# Rezoning Transportation Analysis

Petition Number: 2020-121

General Location Identifier: Tax ID (07110402)

Date	Description
09-14-20	First Review
10-19-20	Second Review

RZ-1.0

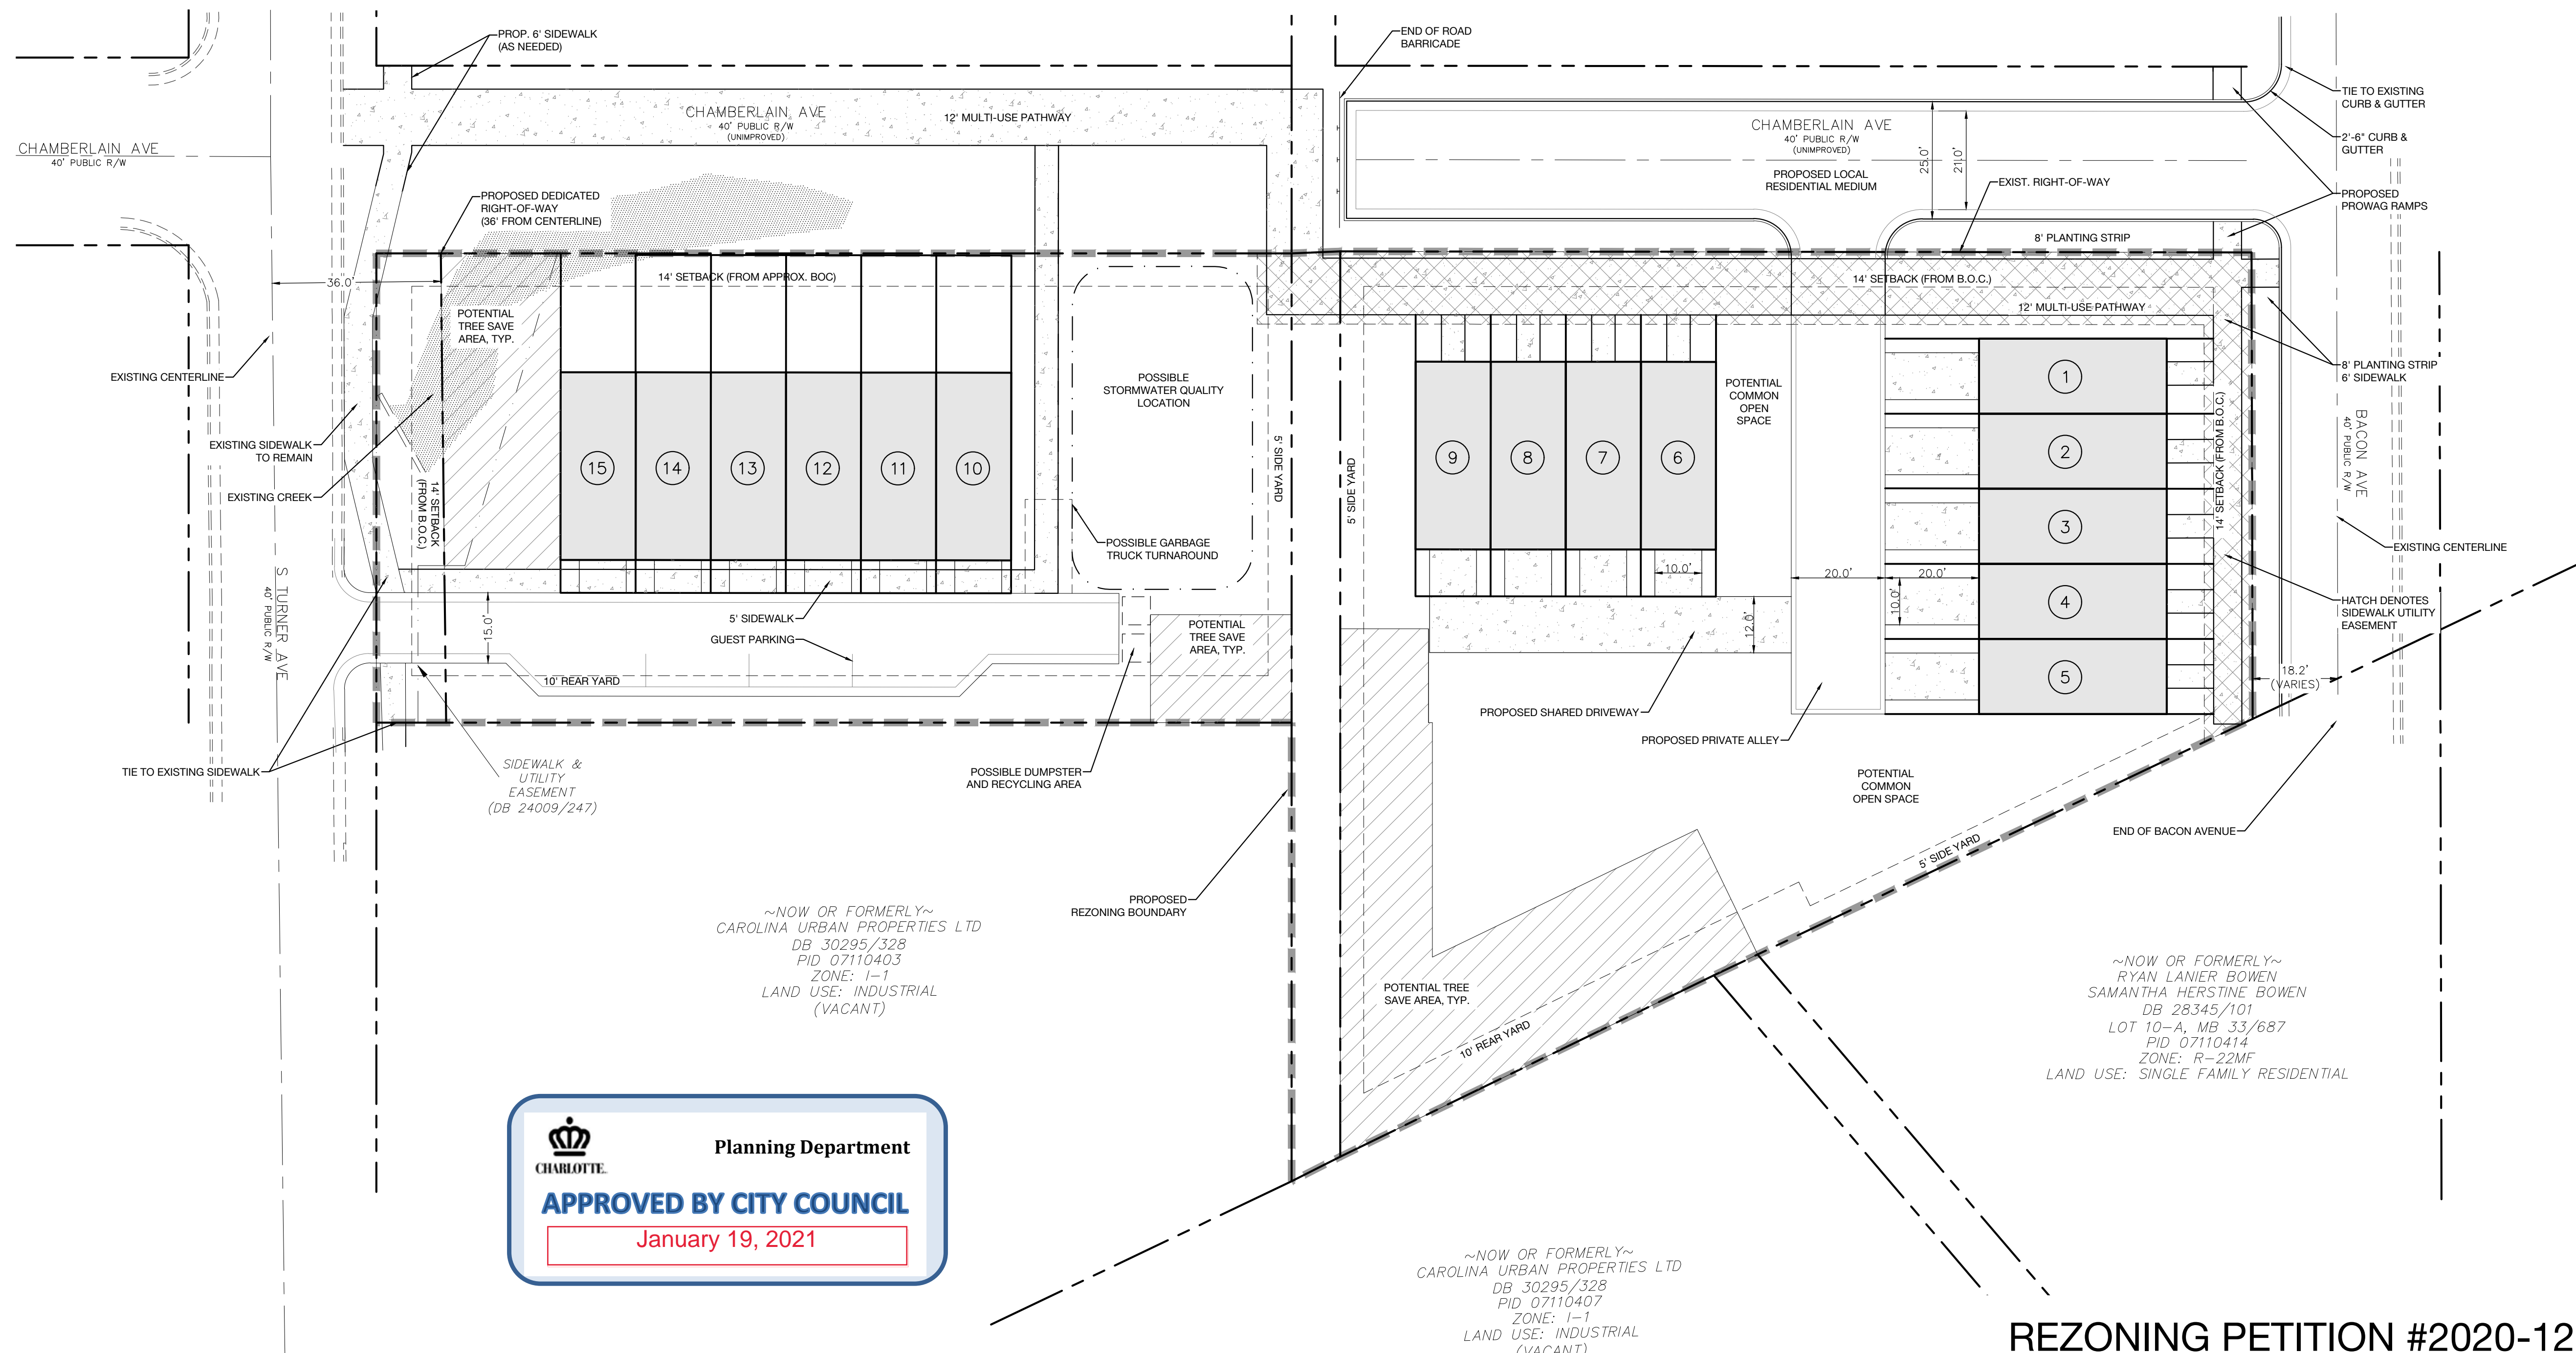
The site is located on Turner Avenue, a collector road. CDOT requests a 16-foot Multi-Use Path, as opposed to the typical 12-ft, to ensure connectivity and gain Powell Bill funding. The petitioner will provide an 8-ft planting strip and 6-ft sidewalk along Bacon Avenue, with accessible ramps. The existing sidewalk along South Turner Avenue will remain. The petitioner will also dedicate additional right of way along South Turner Avenue.

- ~~3. Revise the site plan and conditional note(s) to commit to dedicate 36-feet of right-of-way from the Turner Avenue road centerline, labeled and dimensioned from the road centerline, in accordance with Charlotte Land Development Standards Manual (CLDSM) Urban Street Design Guidelines (USDG) standard detail number **U-07 – Local Collector Street Typical Section.**~~

- ~~4. As per discussions with the Charlotte Planning Subdivision Group, the Chamberlain Rd. connection is required, but due to site constraints, a Multi-Use Path is being substituted for the completed street.~~

- ~~5. Revise the site plan and conditional note(s) to provide two PROWAG ramps per intersection corner, at the intersection of Chamberlain Avenue and Bacon Avenue, if roadway is constructed within the Chamberlain Avenue unmaintained right-of-way.~~

- ~~6. Revise the site plan and conditional note(s) to tie in the proposed multi-use path at the Turner Avenue and Chamberlain Avenue intersection.~~

- ~~7. Revise the site plan to add a note specifying dedication and fee simple conveyance of all rights of way to the City before the site's first building certificate of occupancy is issued. CDOT requests right of way set at 2' behind back of sidewalk where feasible.~~
- ~~8. Revise the site plan to add a note specifying all transportation improvements will be approved and constructed before the site's first building certificate of occupancy is issued. The petitioner may phase transportation improvements if said improvements and phasing are explicitly described in site plan notes.~~
- ~~9. To attain a street and pedestrian lighting recommendation, the petitioner should coordinate with Anthony Mendez, CDOT. Please visit the following link:  
<https://charlottenc.gov/Transportation/Programs/Pages/StreetLighting.aspx>~~
10. **Resolved** Sample format for comment that is resolved
